Appeal Decision

Appeal Ref: APP/Z4718/W/23/3335079

Hill Farm, Chain Road, Slaithwaite, Huddersfield HD7 5TZ

- The appeal is made under section 78 of the Town and Country Planning Act 1990 (as amended) against a refusal to grant [outline] planning permission.
 - The appeal is made by Mr James Keats against the decision of Kirklees Metropolitan Council.
 - The application Ref is 2023/62/90569/W.
 - The development proposed is described as the "Erection of Agricultural Barn".
-

drawing PROPOSED ELEVATIONS AND VIEWS

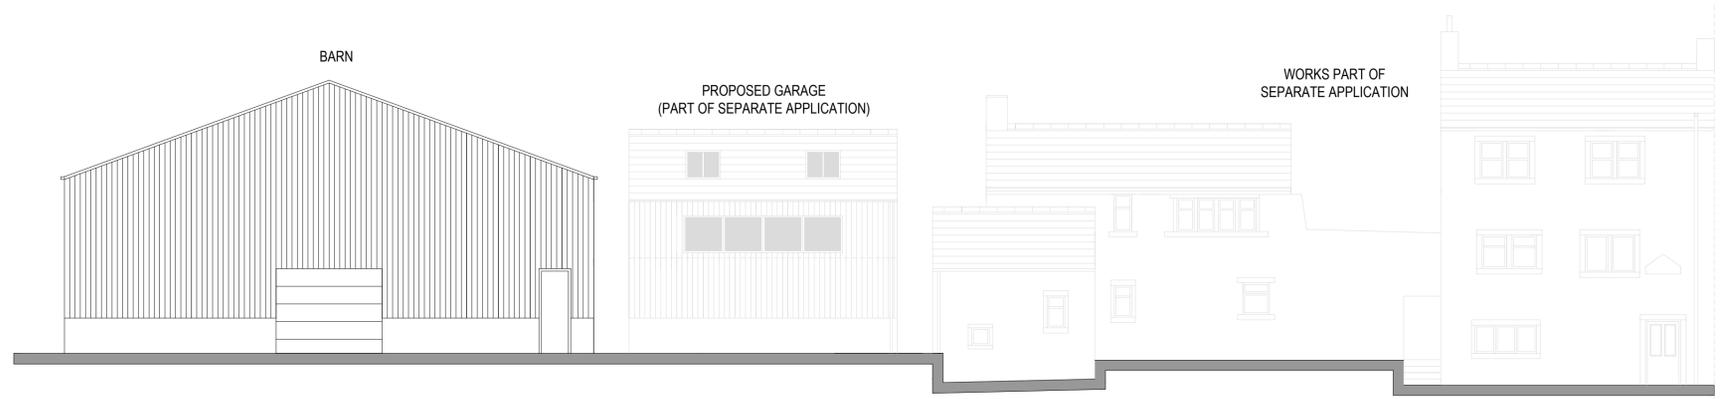
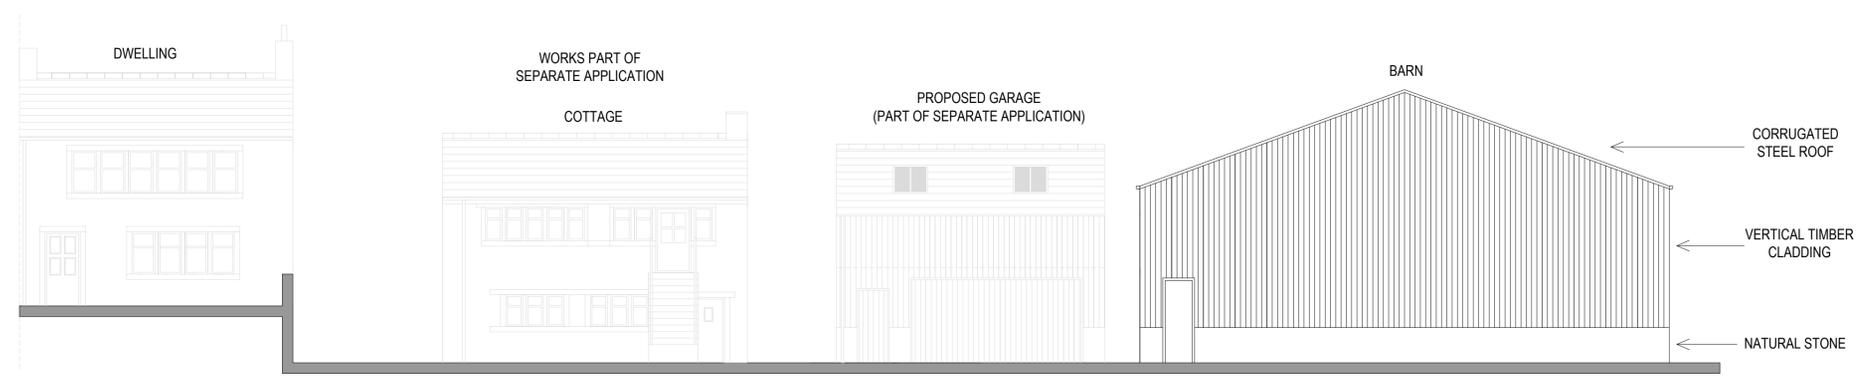
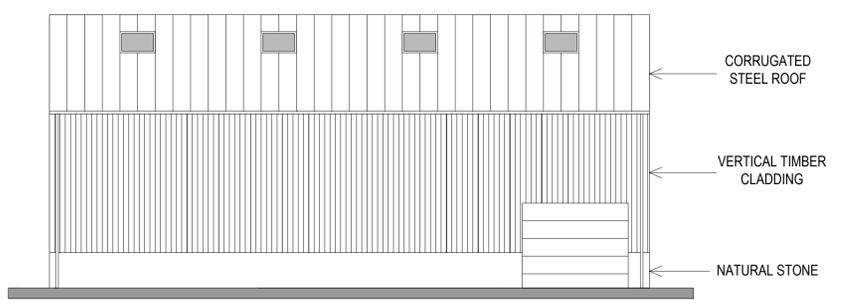
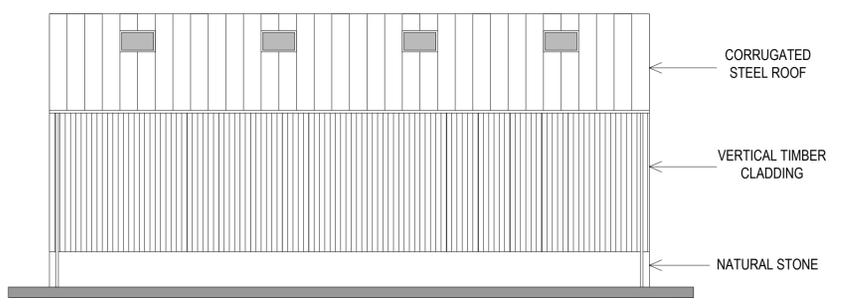
14. Turning the size and scale of the proposed barn, the submitted plans show the building as being some 7.7m to the ridge, and with a footprint of some 17 x 15m. Consequently, the barn will appear as a large structure in itself and in comparison, to the modest massing of the DHA, in particular because of the close proximity of the proposed structure.

16. Furthermore, the submitted plans show the height of the barn as being comparable to the height of the adjacent cottage and, as result in a change in ground levels, the dwelling. Additionally, there is a distinct separation between the barn and the adjacent cottage, albeit shown on the submitted plans as being filled by a second building annotated as being the subject of a separate planning application. The elevations of the proposed barn are shown as including natural stone and timber, materials that are reflective of the area.

client	JAMES KEATS AND SHONA SEARSON		
project	PROPOSED BARN HILL FARM, CHAIN ROAD MARSDEN HD7 5TZ		
drawing	PROPOSED PLANS		
revision	notes	date	drawn
scale :	1:100 AT A1	02.23	MG
project no.	2228	drawing no.	02
		revision

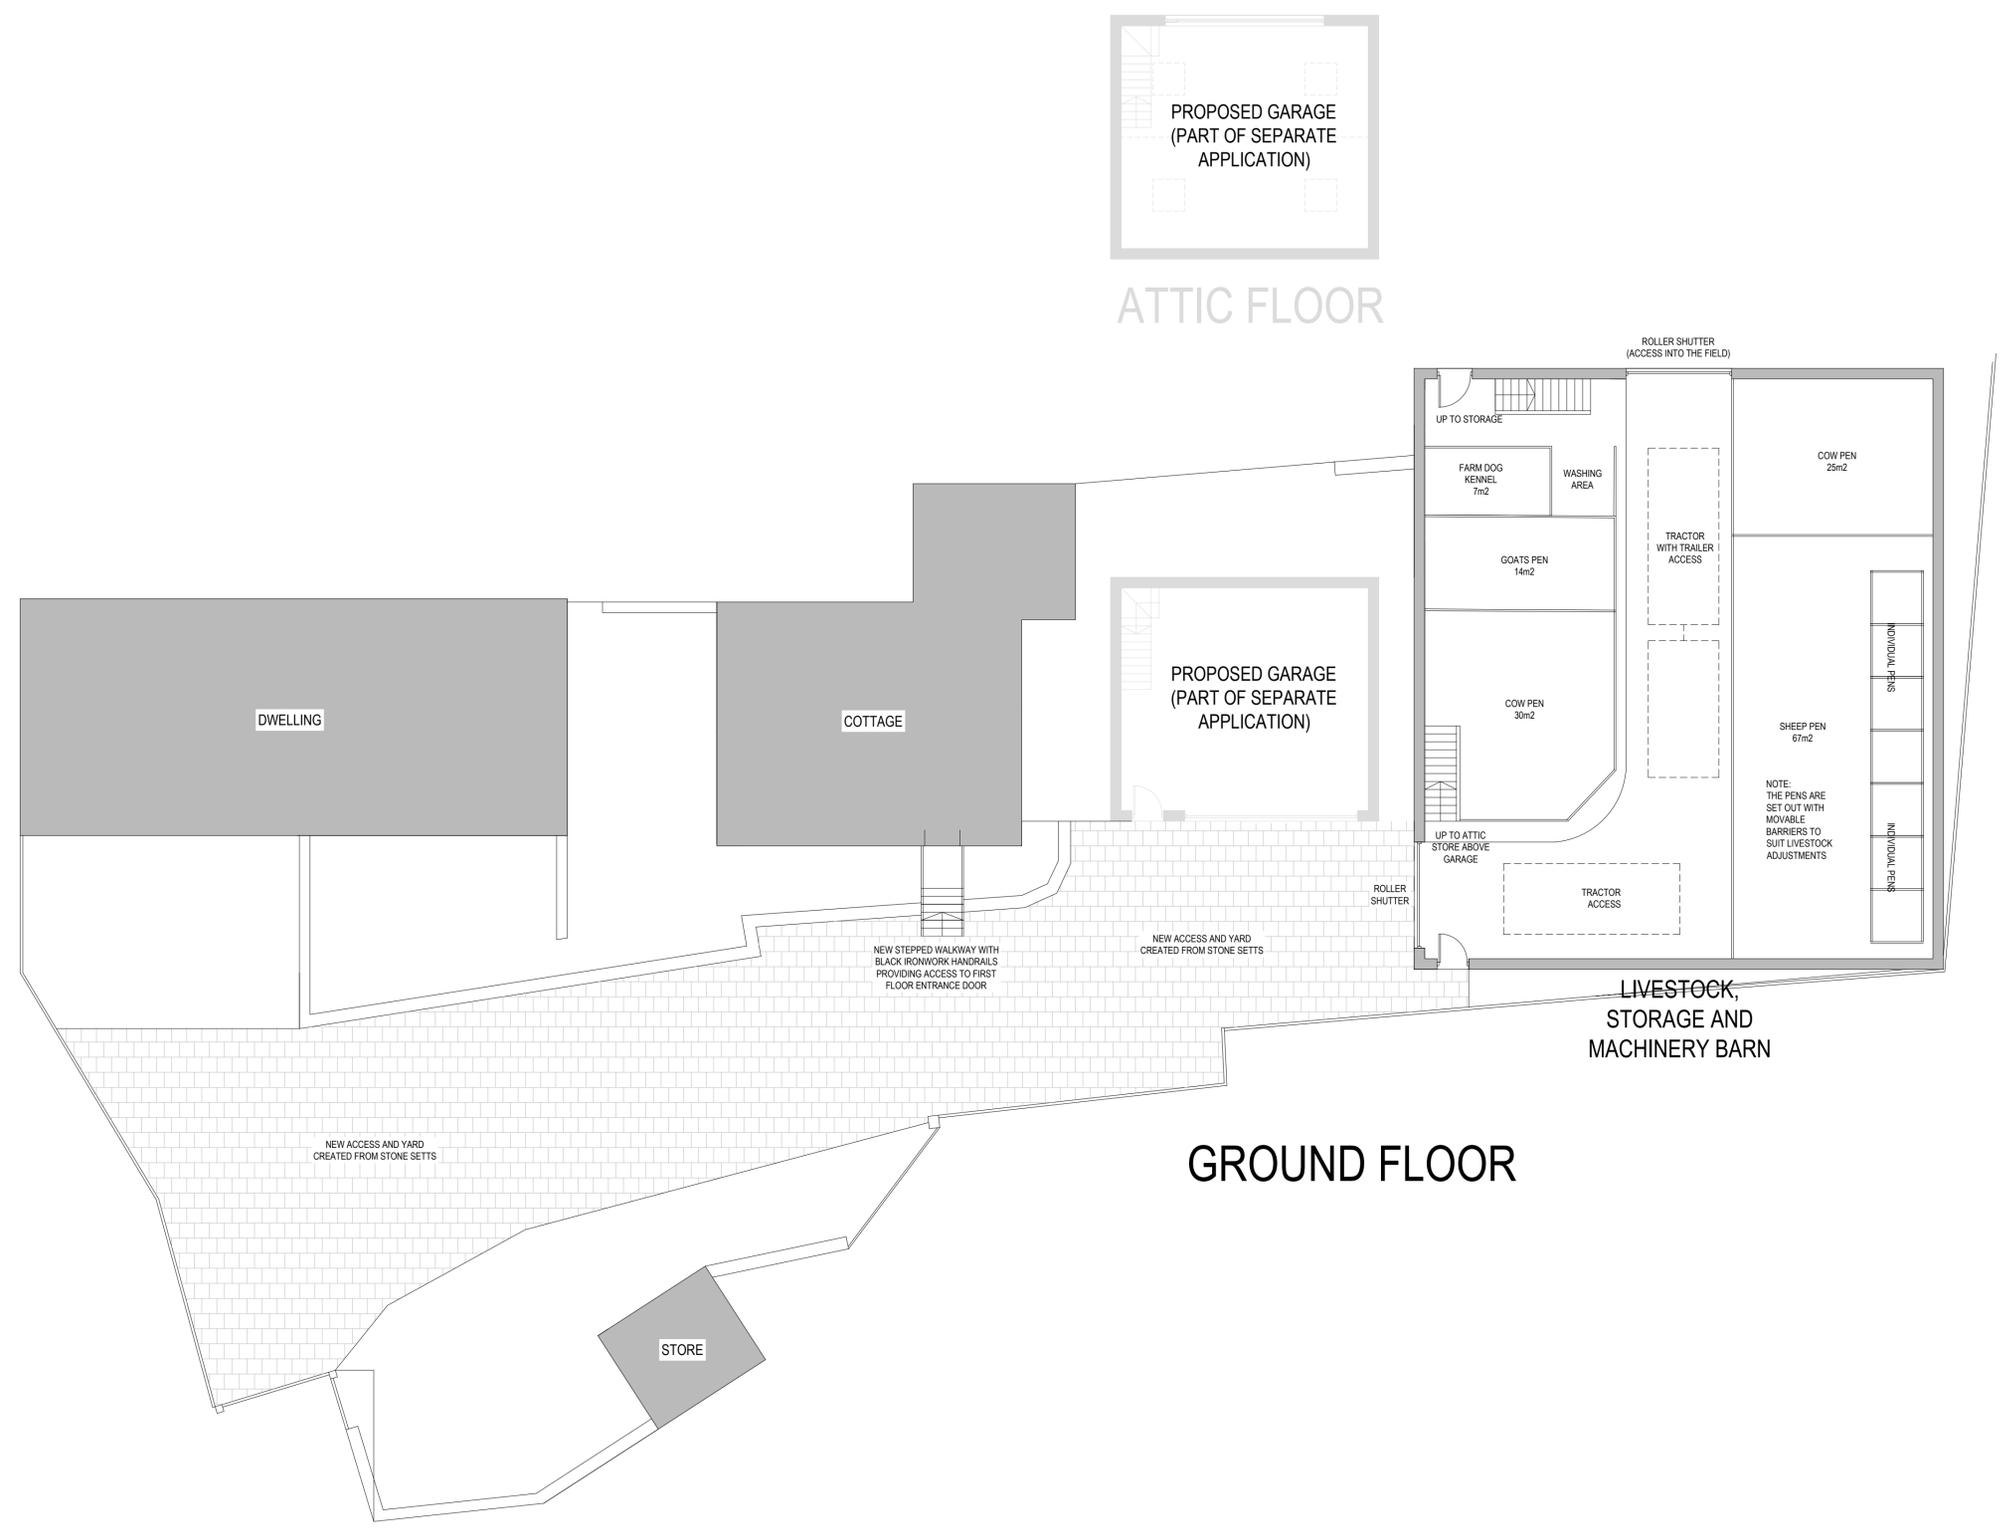
7. The Council expressed doubt as to the need for the compartmentalisation of the barn shown on the submitted plans, the through access for vehicles, the area set aside for the dog, as well as noting that amongst other matters, the proposed building will accommodate more animals than are detailed as being on the farm at this time. Cumulatively, the Council asserts that the appellant has failed to demonstrate that the building is genuinely required for the purpose of agriculture.

8. The appellant describes a growing small holding on 5 acres of land. The appellant justifies the size of the building with reference to the need to accommodate animals, in particular over the winter. Furthermore, the herd would increase to 20 sheep, 2 goats, and 4 cows. The appellant provides a detailed breakdown of the space within the barn, referring to British Standards and the RSPCA guidelines to justify the size and scale of the barn. The appellant details that there is sufficient grazing land for additional animals but that they lack the winter accommodation. I have no substantive evidence to the contrary.

9. Even if I were to agree with some of the space savings measures identified by the council, the resulting reduction in the size and scale of the proposed barn would, in overall terms, be modest.

10. I consider that, based on the evidence before me, the appellant has demonstrated that there is a need to accommodate livestock and farm

machinery. Therefore, I consider that it has been satisfactory been demonstrated that there is an agricultural requirement for the proposed development and therefore the appeal scheme is not contrary to Policy LP54(A) of the Kirklees Local Plan.
